Case Officer: Simon Newall

Applicant: Bicester Gateway Ltd

Proposal: Reserved Matters to 16/02586/OUT - Access, layout, scale, appearance and landscaping details for Phase 1B for up to 12 No knowledge economy units in Use Class E (former Use Class B) (14,972 sq m gross external area) with associated parking, landscaping, utilities and access

**03** Type 3 - Elevation View  
 MOUND SOFT TREE PIT 1:20

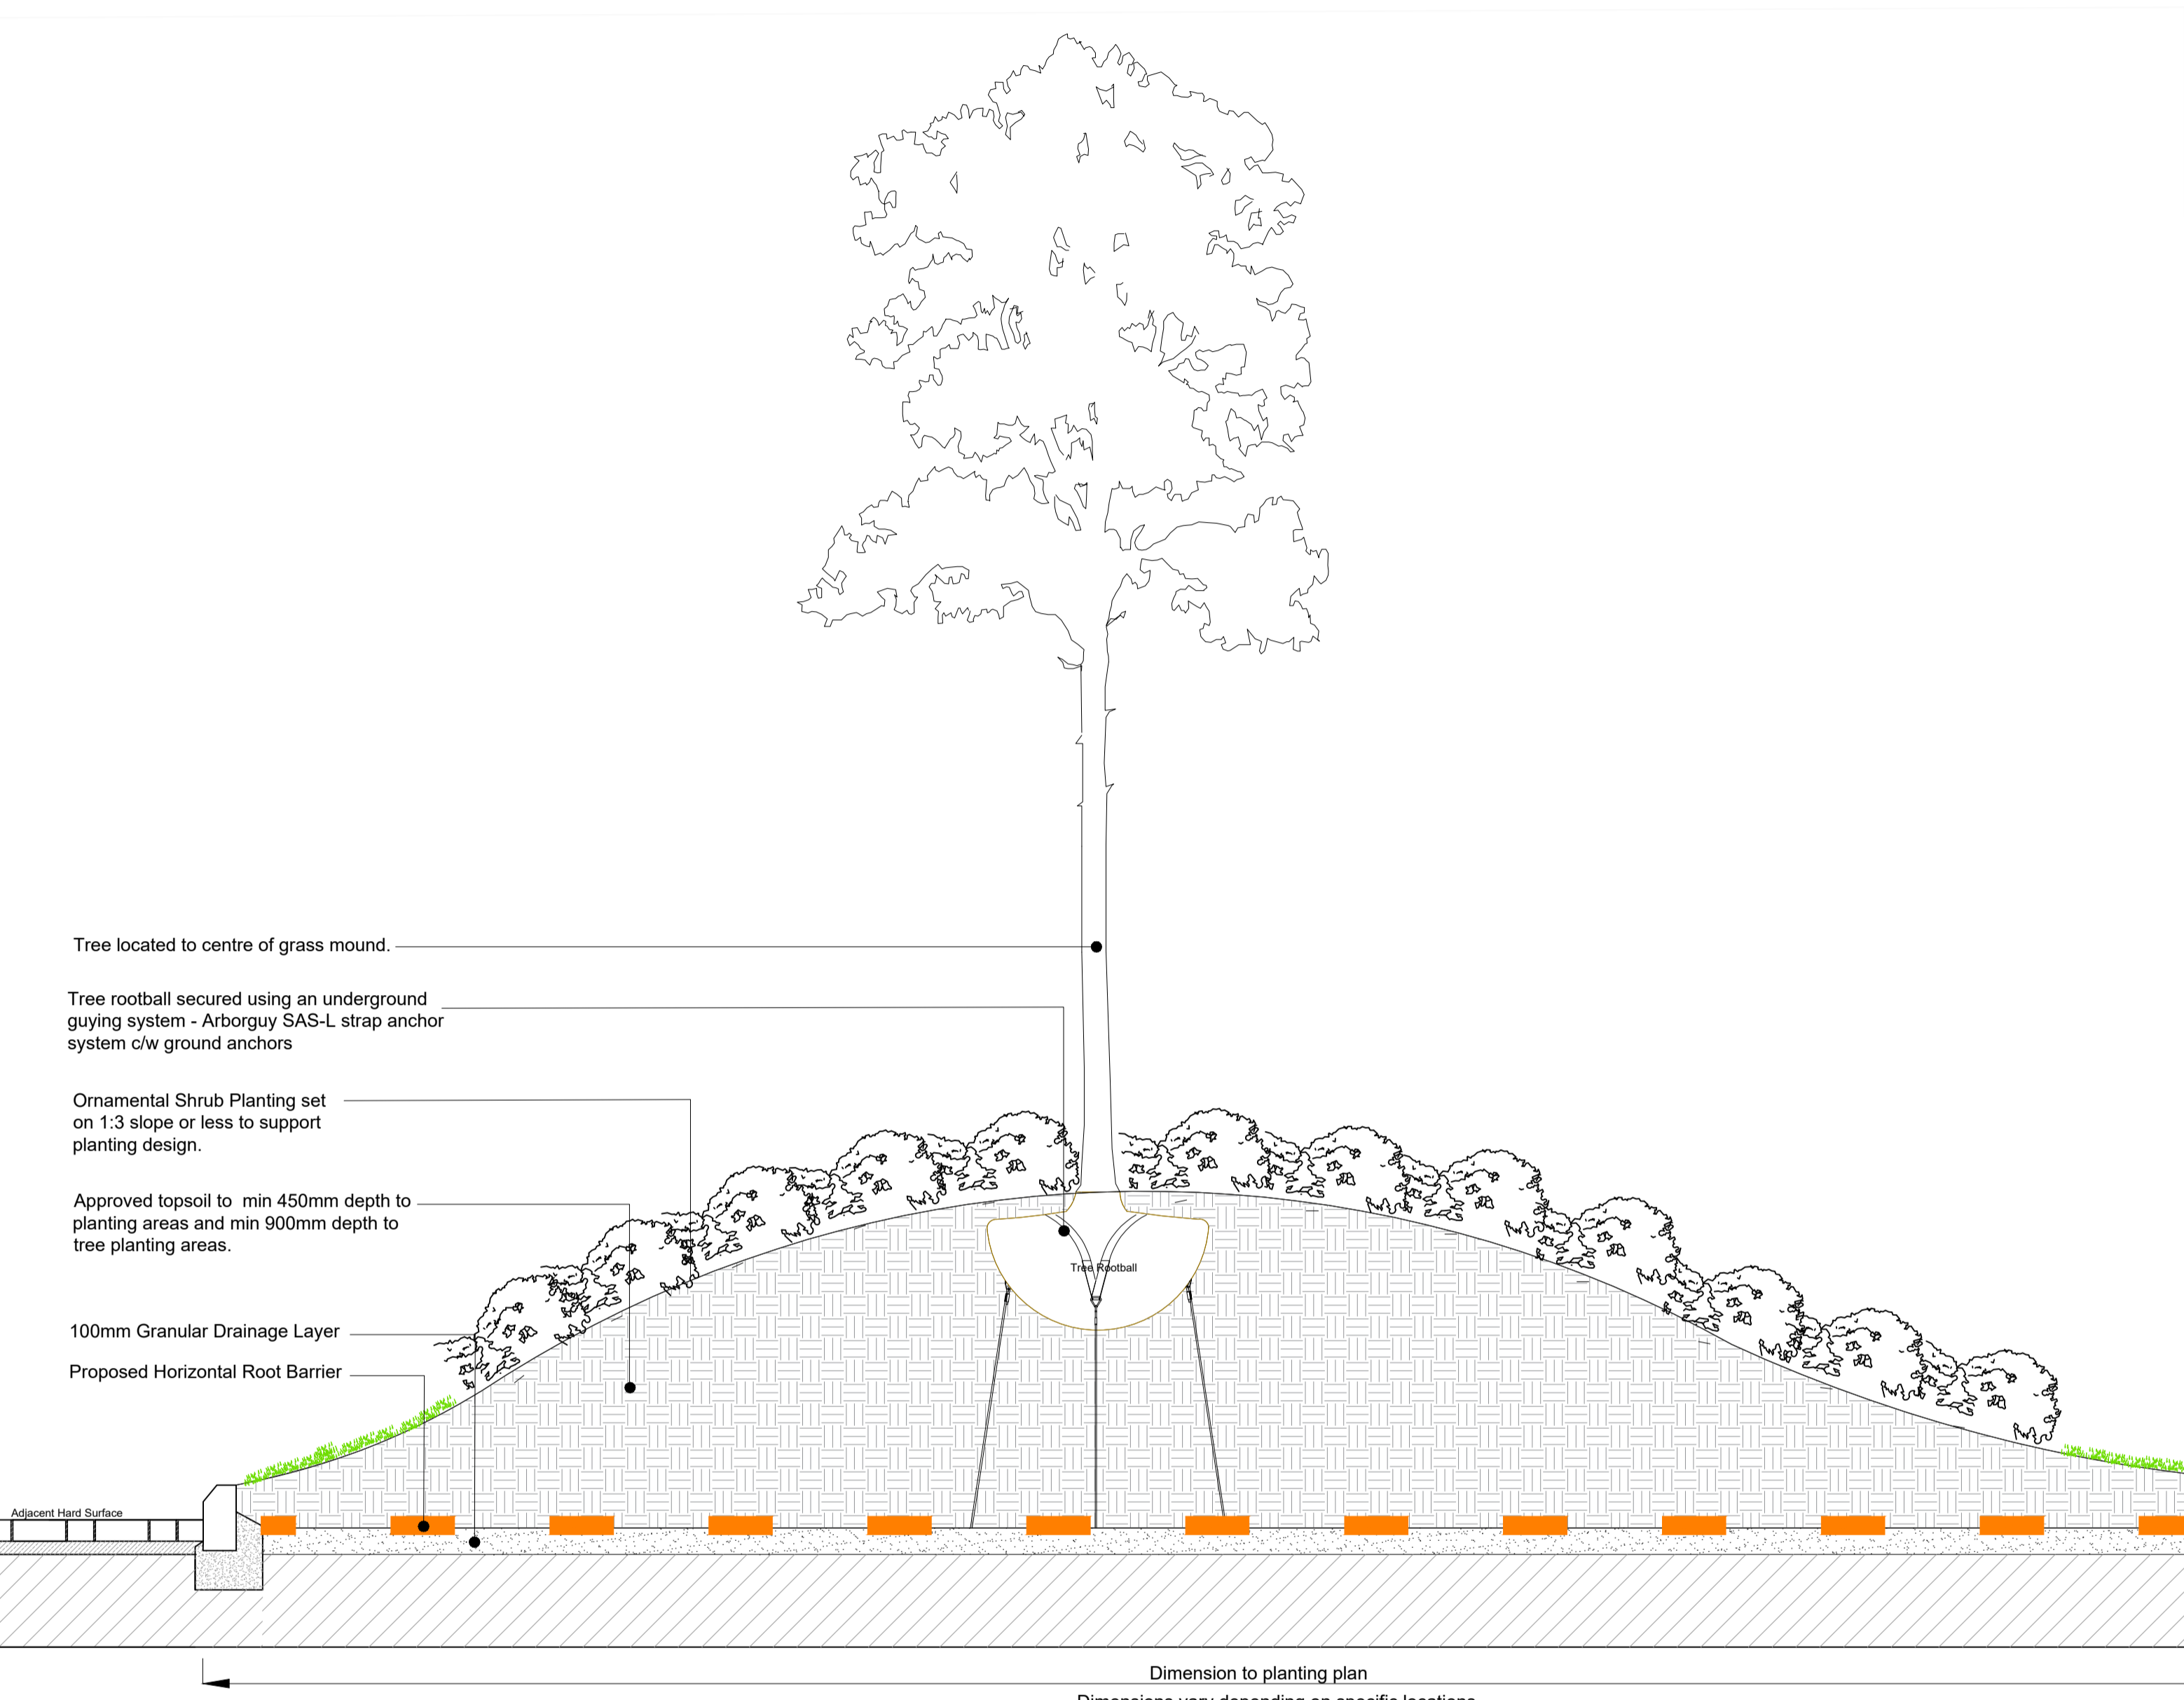
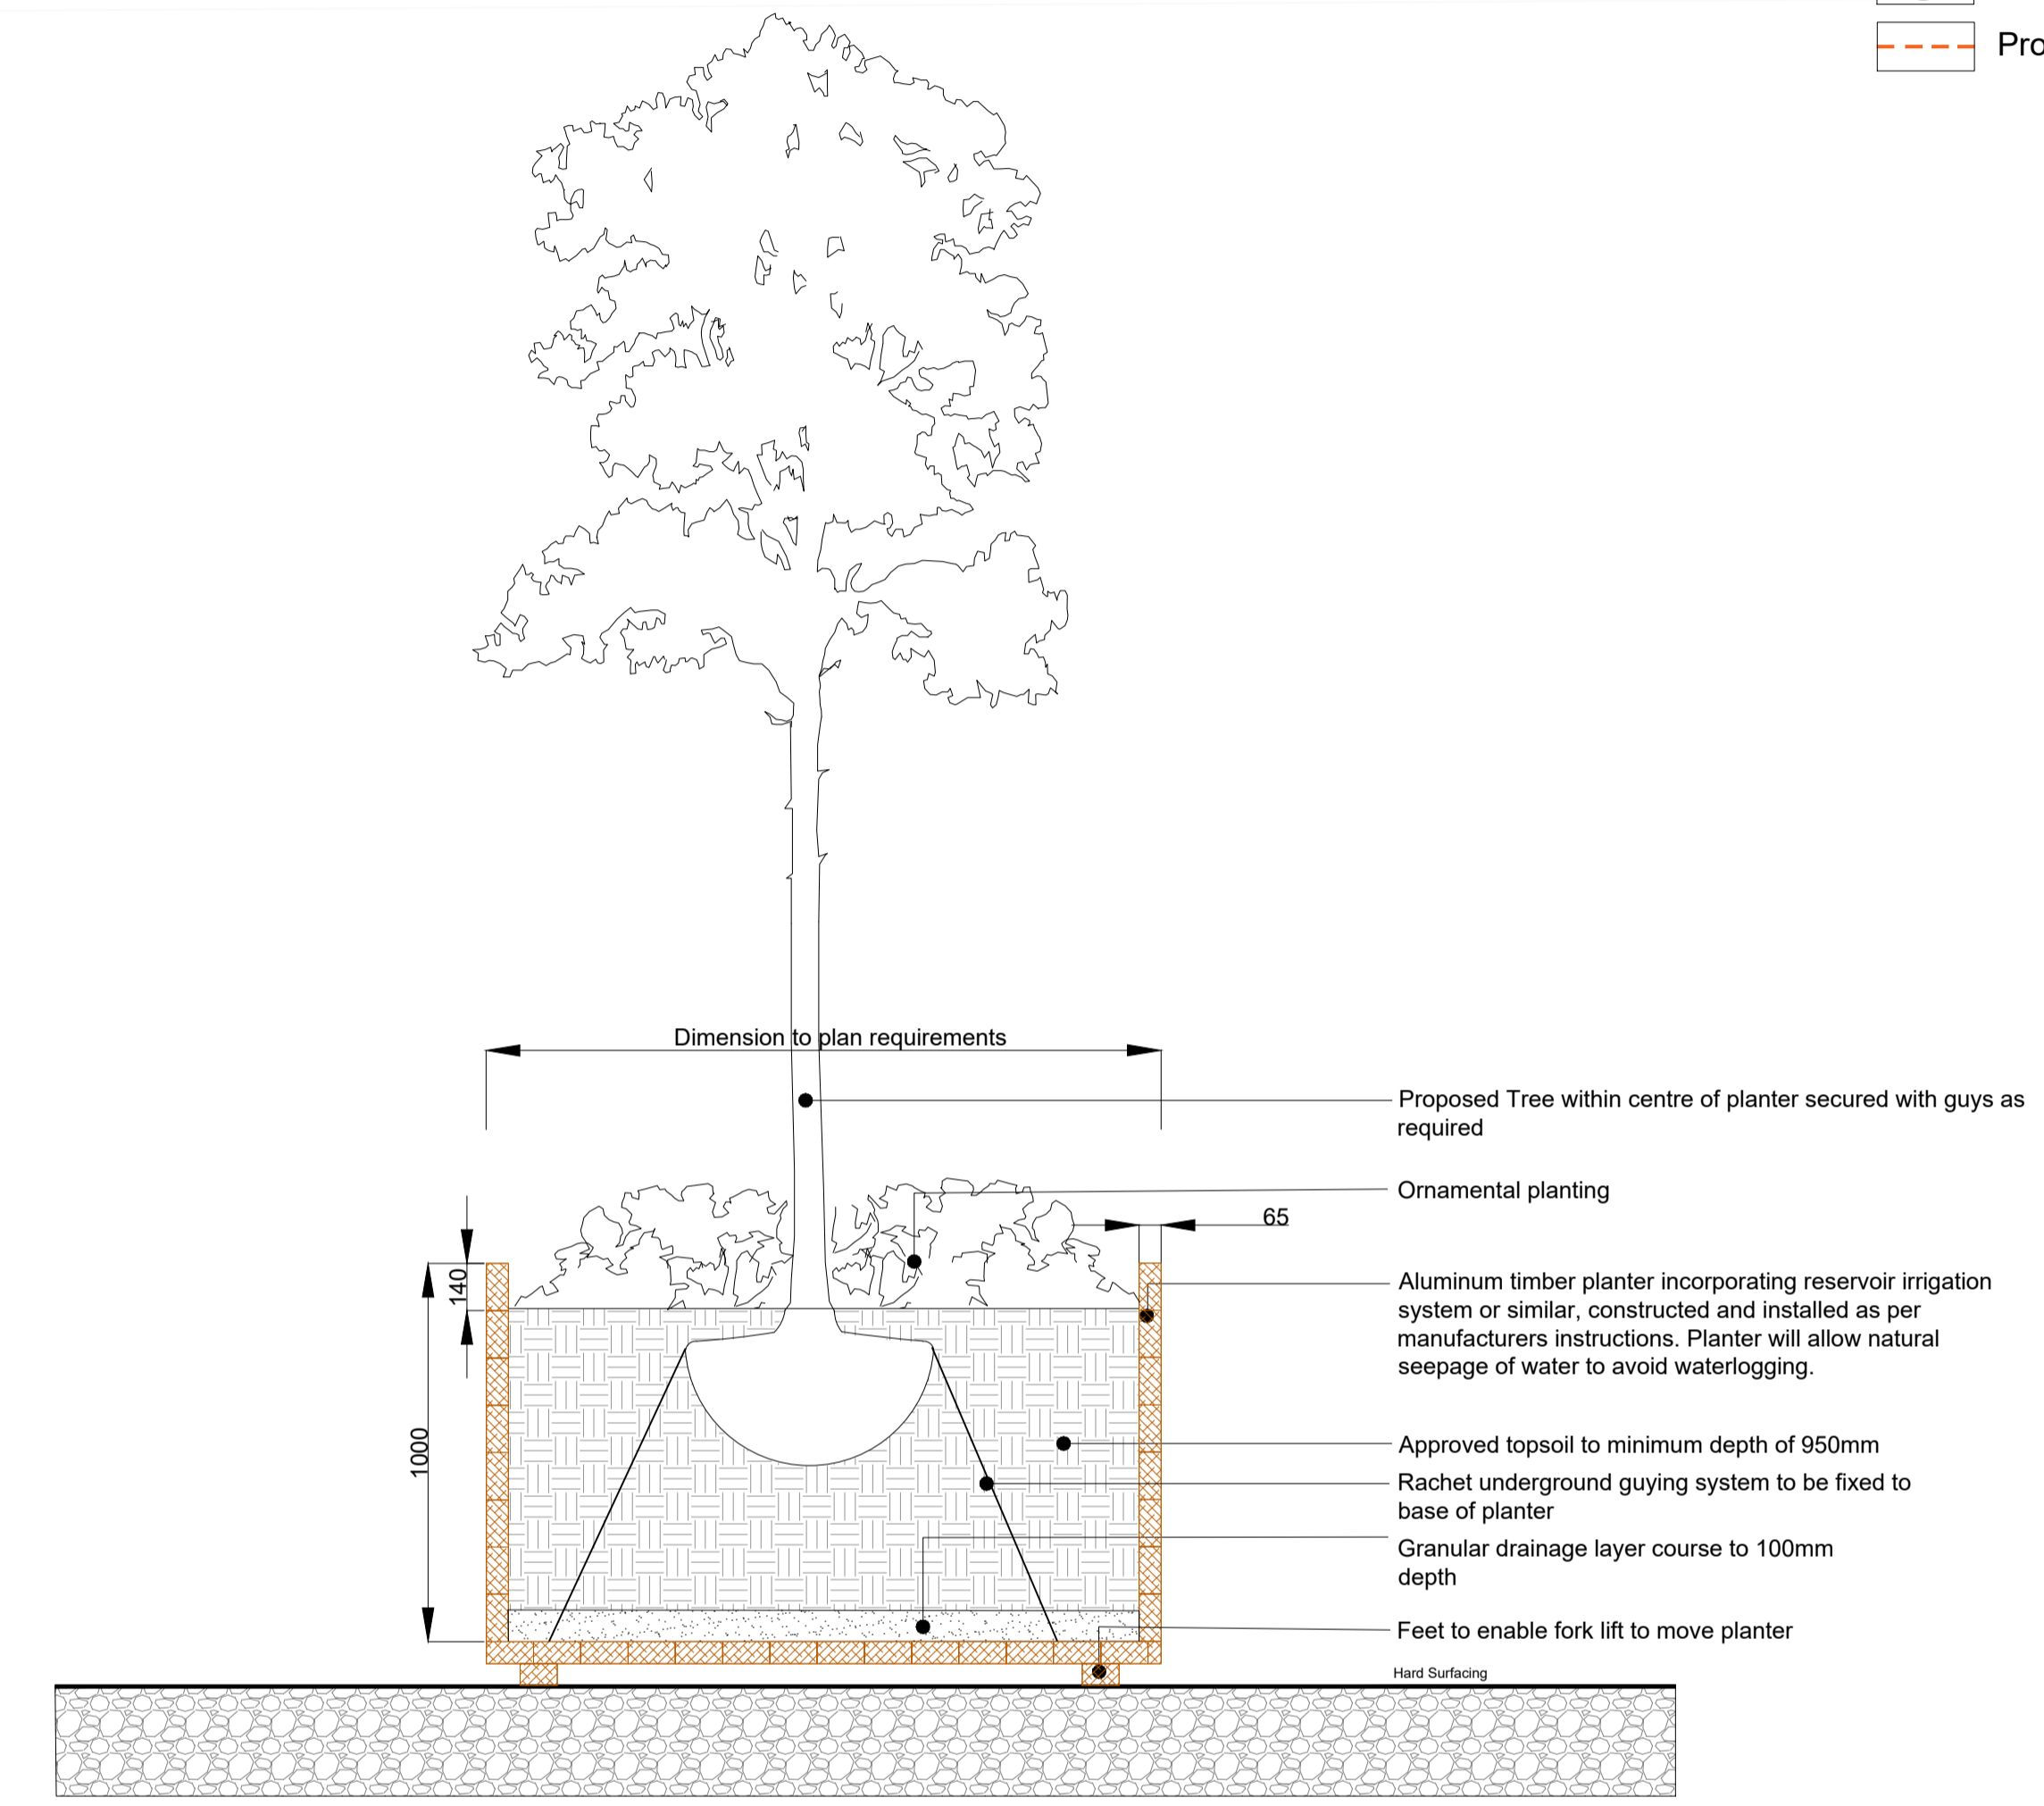
- Mounds: It is not clear where the tree mounds are proposed and what tree species are being used for this. Sufficient amount of space will be required to accommodate trees on mounds

- Indication of tree pit details and root deflectors on the relevant plans, with tree clearly set out within the planting plans on mounding and elsewhere.
